Application for Removal or Variation of a Condition following Grant of Planning Permission or Listed Building Consent

Demolition and replacement of the existing detached dwelling and garage, with a new detached two storey dwelling (including habitable roof space with 2 front and 2 rear dormers, 6 roof lights and a basement) and associated landscaping and ancillary works.

47172/APP/2022/3635

Approved Drawings: 1393/P/1A, 2A and 3A

drawing: PROPOSED ELEVATIONS

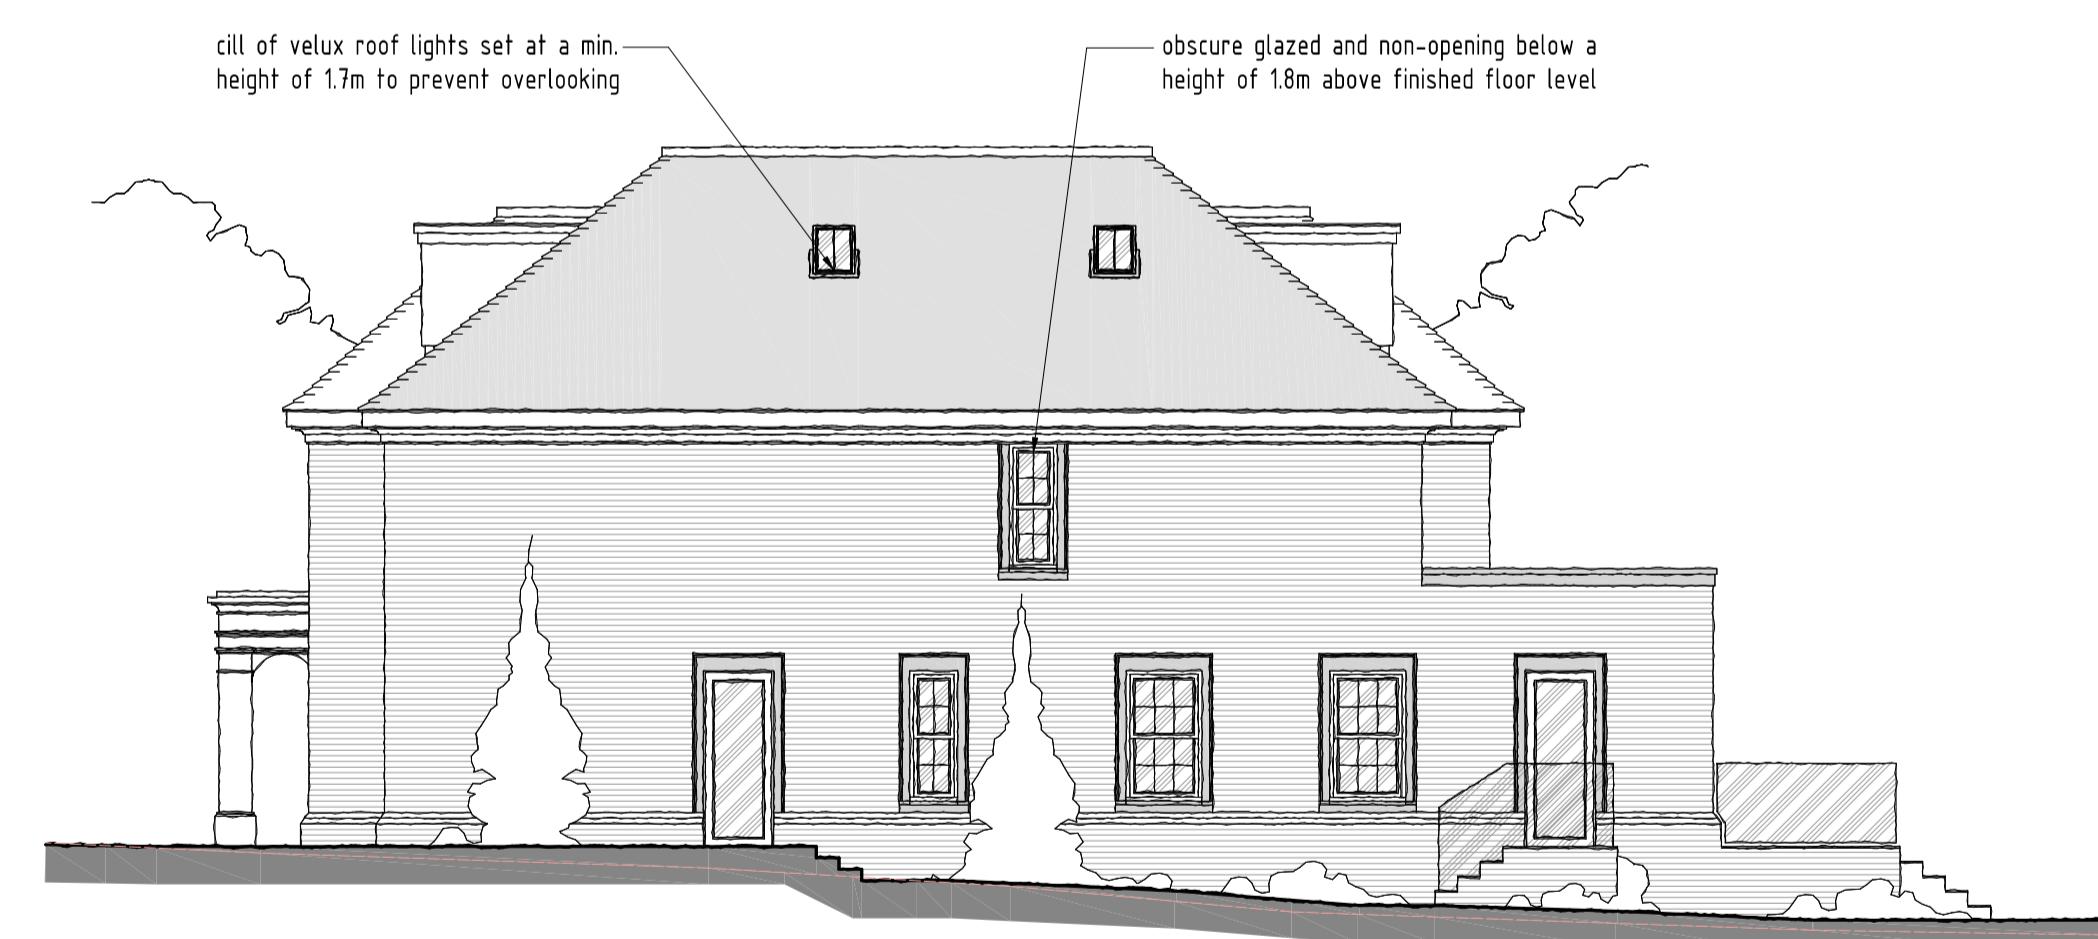
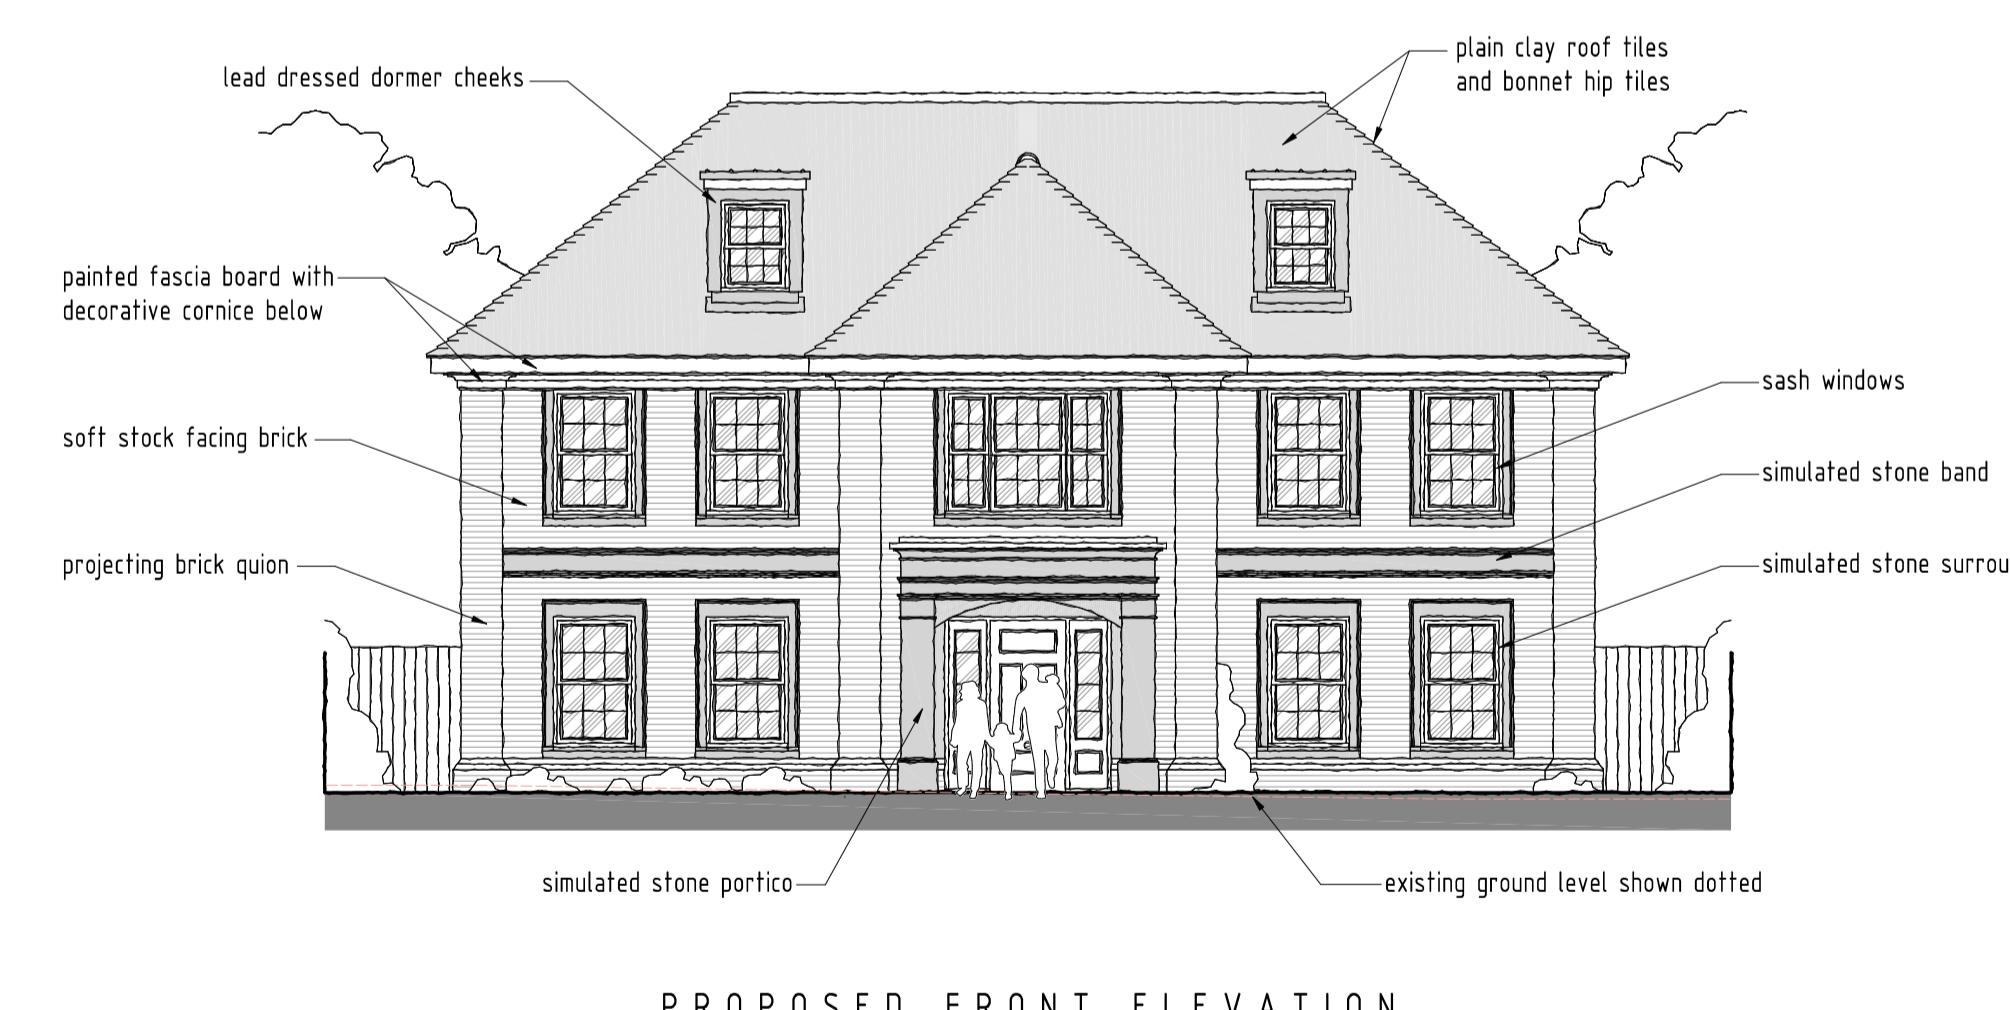
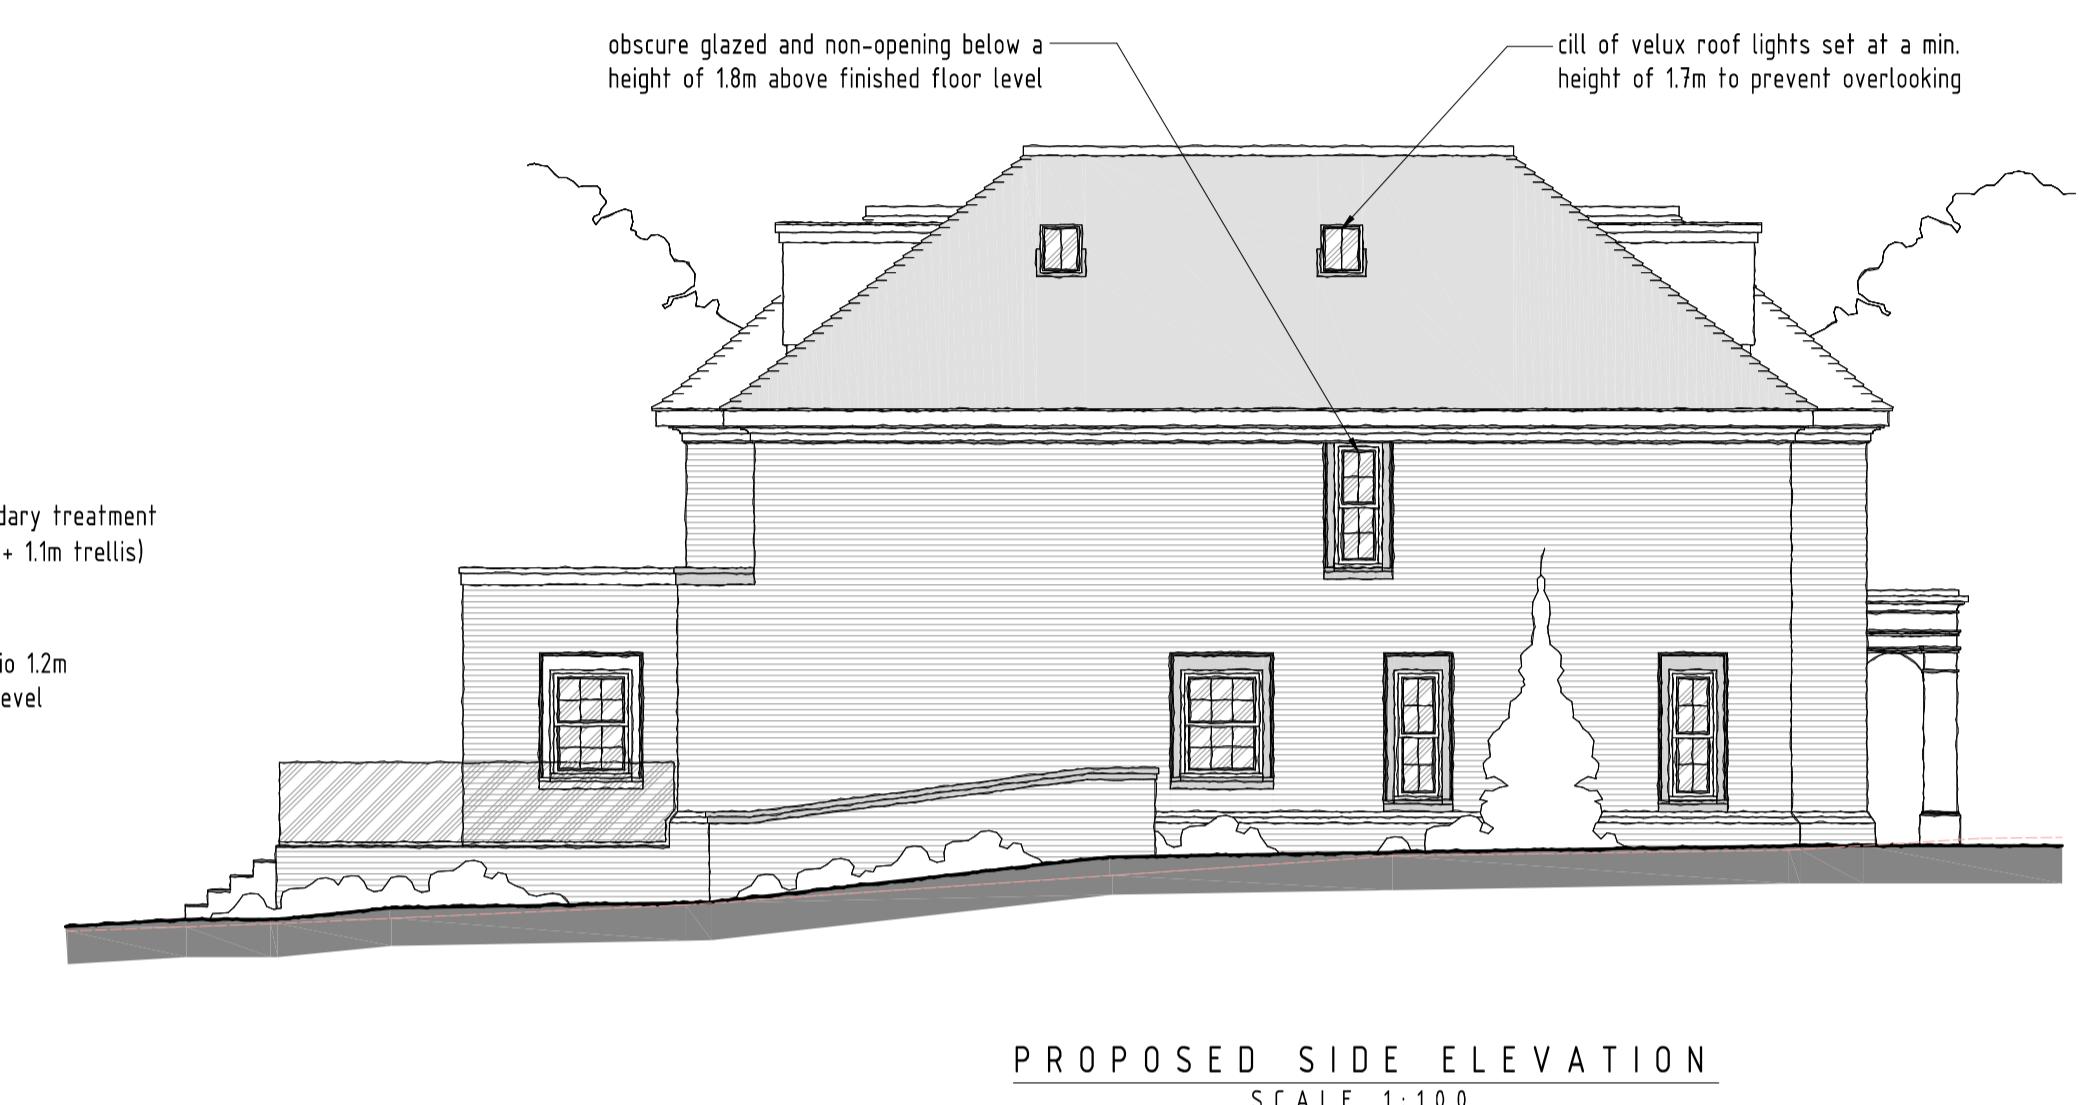
1. Garage doors replaced with windows (garage store changed to study).

2. Velux rooflights removed.
3. Window / door sizes changed.
4. Rear wall (master dress & en-suite) pulled out 980mm.
5. Single storey element reduced in depth, and covered courtyard added to basement (replacing games room).

6. General changes to window positions, size and number.
7. Side access steps added to new door into spice kitchen.

Drawing nos, 1393/P/1B, 2B and 3B.
